Application for a non-material amendment following a grant of planning permission.

The addition of a window to the rear
Changed the description for the proposed roof tiles to match existing
And the addition of two sets of French doors to the front of the property rather than windows.

Reference number:	FG/112/21/HH
-------------------	--------------

2068 46 Ferringham Existing and Proposed Rev3

A 02

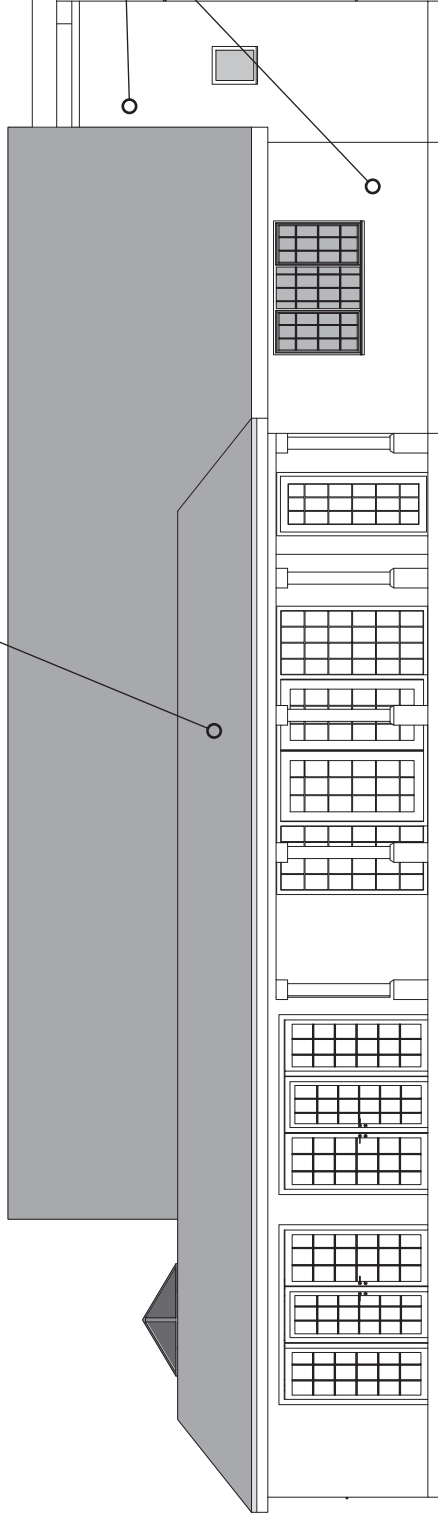
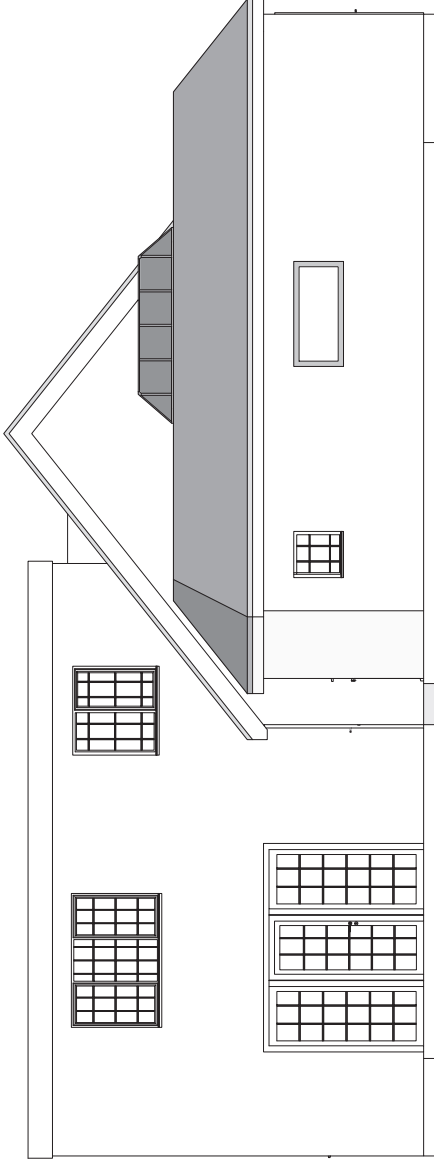
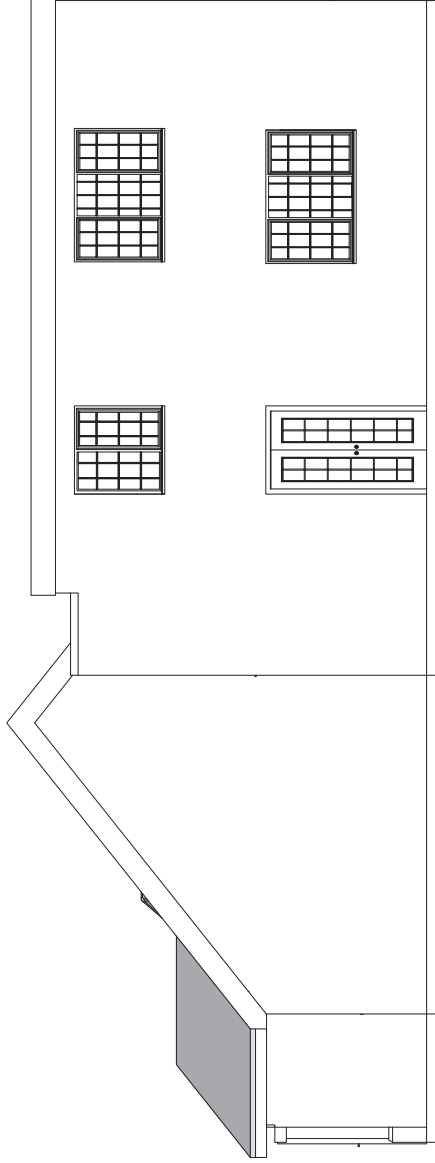
- The addition of a window to the rear
- Changed the description for the proposed roof tiles to match existing
- And the addition of two sets of French doors to the front of the property
